From: Anita Gardner
Sent: 04 June 2019 14:29
To: Planning.Responses
Subject: FW: AB/32/19/L - 13 Mount Pleasant Arundel BN18 9BD
Attachments: 0273_102B Pr plans.pdf; 0273_103B Details.pdf; Dale-brochure-2018-LR-spreads(3).pdf

From: Peter Davey [REDACTED]
Sent: 04 June 2019 14:14
To: Anita Gardner
Subject: RE: AB/32/19/L - 13 Mount Pleasant Arundel BN18 9BD

client	project	drawing	date	drawn	drawing no	revision
Christine Fowler	New Doors / Windows at Dove Cottage, 13 Mount Pleasant Arundel, BN18 9BD	Proposed floor plan + elevations	Dec 18	pd	0273 / 102	B
			scale	CAD file name:		
			1:100, 1:200 @ A3

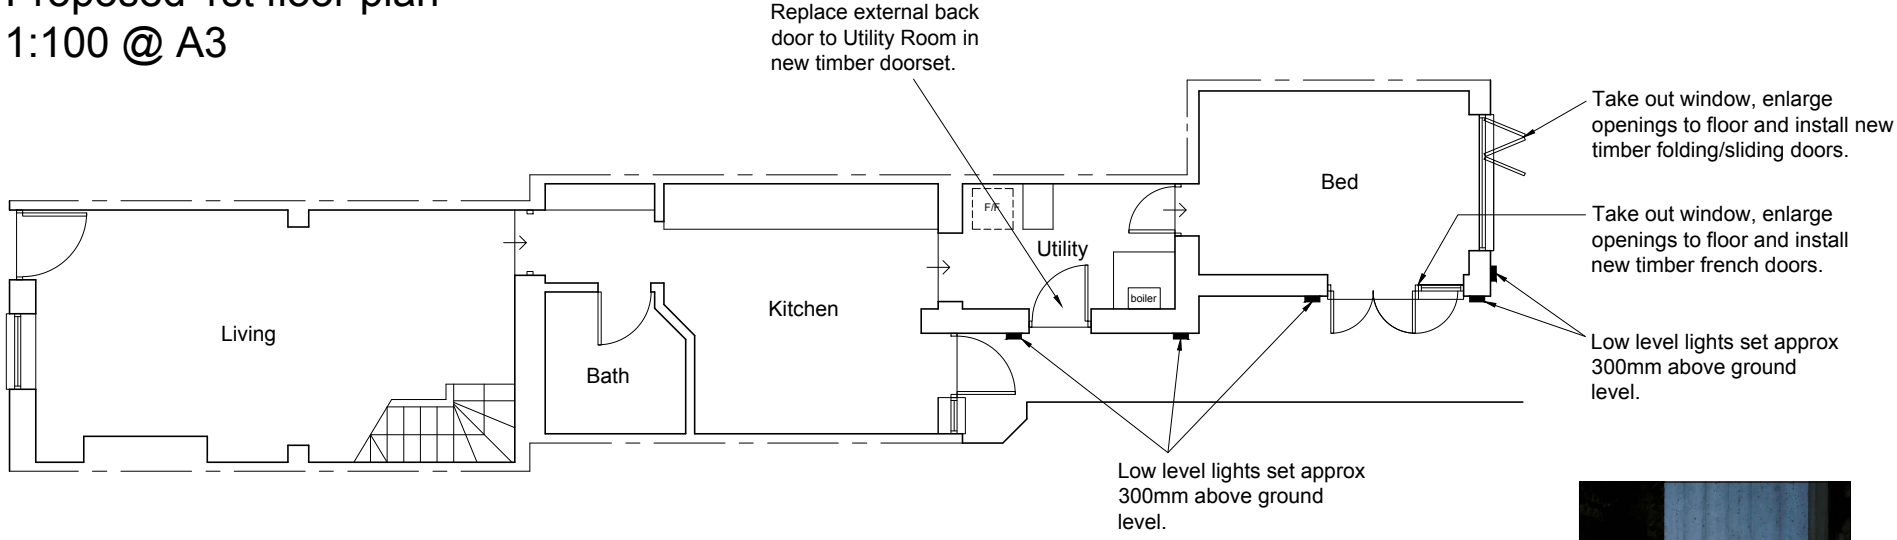
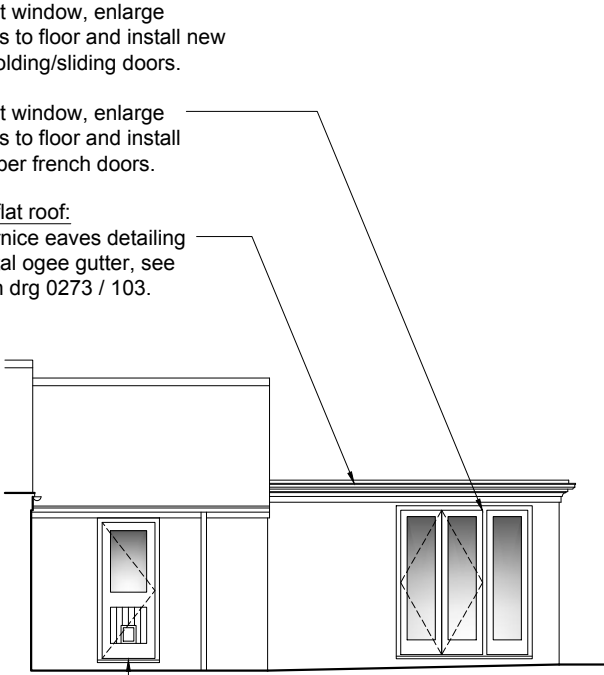
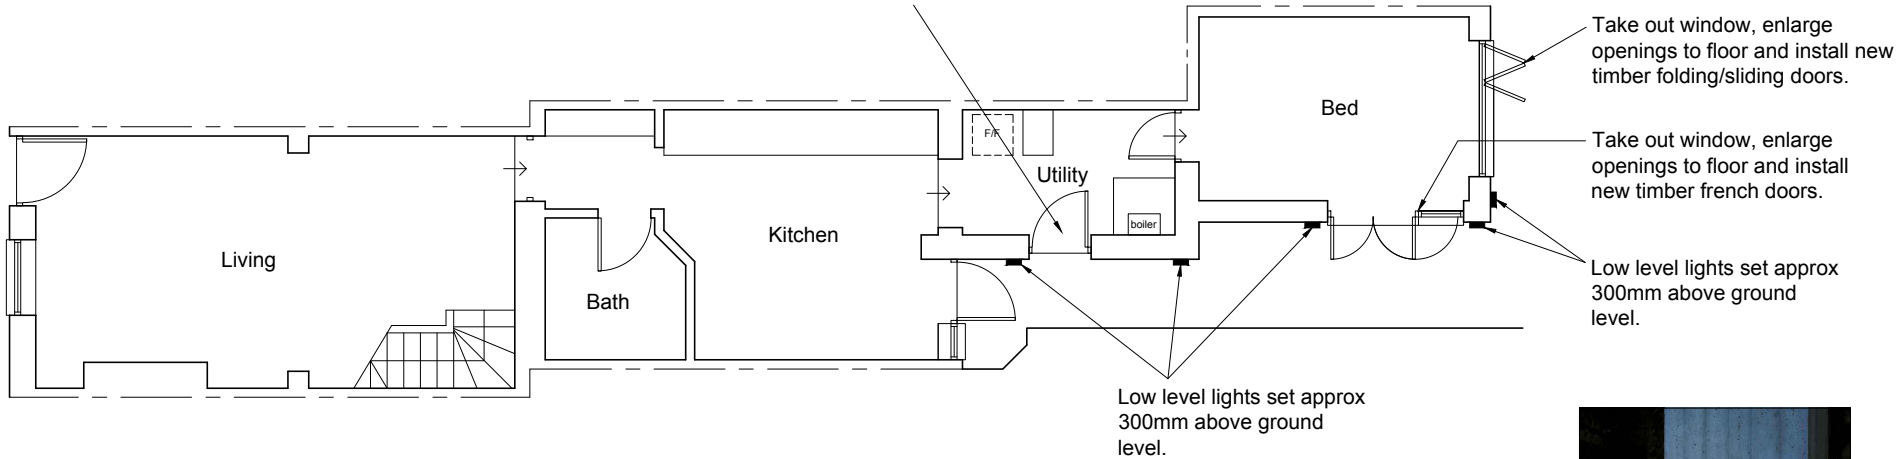
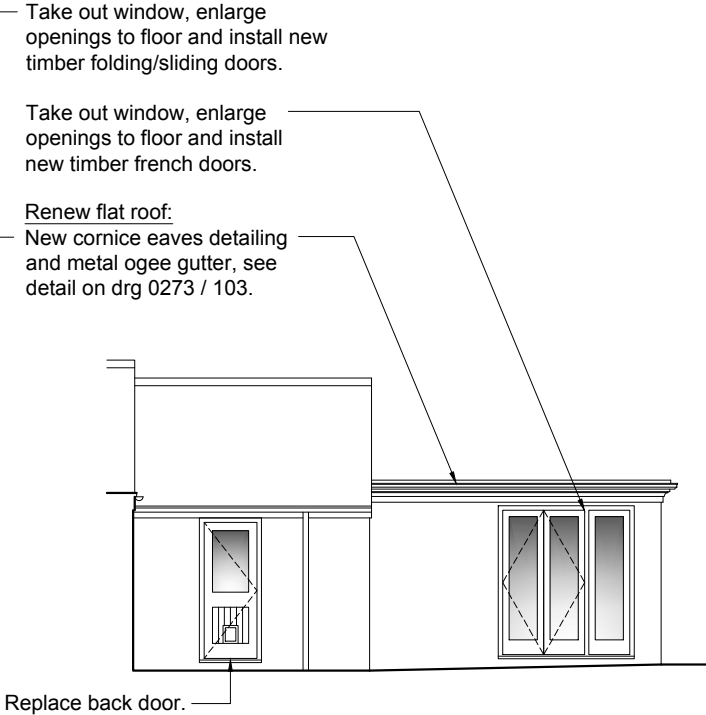
I note that two options have been provided for the low level lighting – please can it be confirmed which is proposed to be used?"

The alternative projecting light fitting has been omitted in favour of the original flush brick design.

Typical horz Section thro
New 2nd floor Window
1:5 @ A3

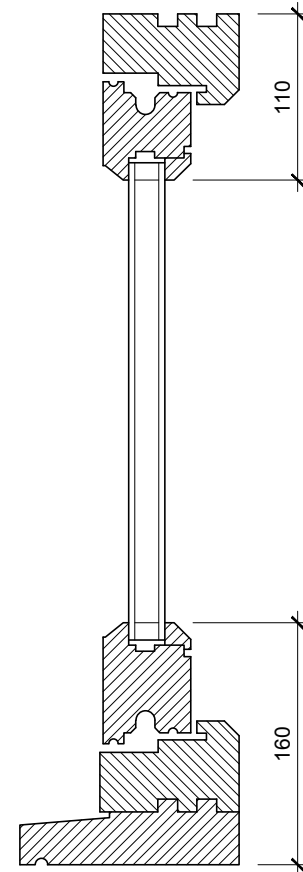
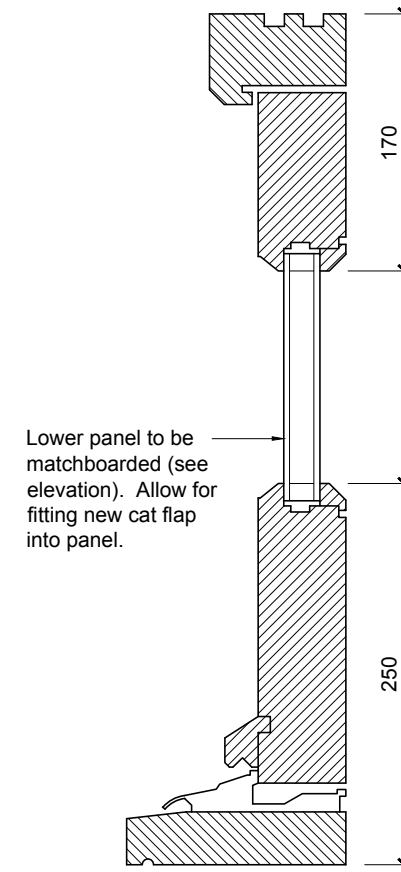
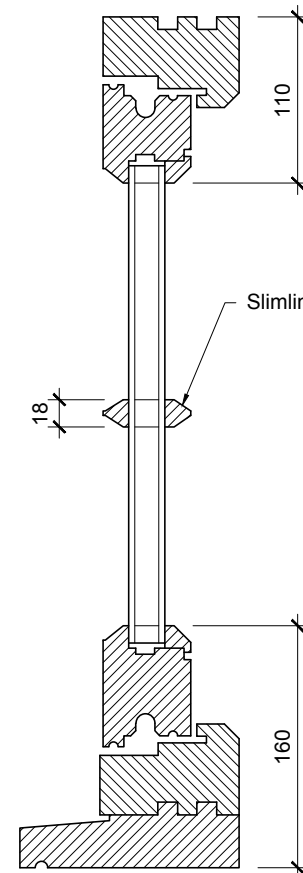
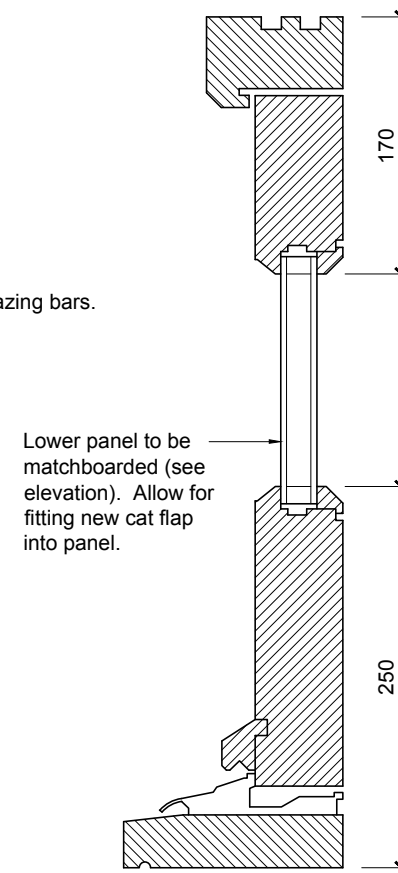
Further to my earlier e-mail I have now received the written comments of the Conservation Officer who has stated "it is not clear how the proposed glazing bars will appear? Will they be integral to the frame or merely placed on the glazing? Further, I note that the proposal is to use double glazed units. Whilst there might be justification for doing this as the loss of the crill windows is an improvement, it is not clear if the units will be of a standard design or the heritage equivalent. By this I mean the slimmer units. Further, no details are provided regarding the glazing bar for the windows; they should be integral to the frames and not merely added as though an afterthought. These details can be provided for by way of condition if minded to approve the application. the colour of the joinery should also match the existing.

I have today spoken to the Conservation officer. Without prejudice, he has requested confirmation of the precise glazing/glazing unit proposed. Is it possible this could be detailed on the cross section? If not further details could be conditioned? Please let me know how you wish to proceed.

The glazing bars are shaped in timber to match the beading. They protrude both sides of the glass with a spacer within the sealed unit to make them indistinguishable from structural bars. If structural glazing bars had been used, it would significantly reduce thermal performance. Also by using double glazed sealed units, a structural glazing bar would have to be much heavier in profile which would not be in keeping. This proposal allows the use of slimline bars to match the original.
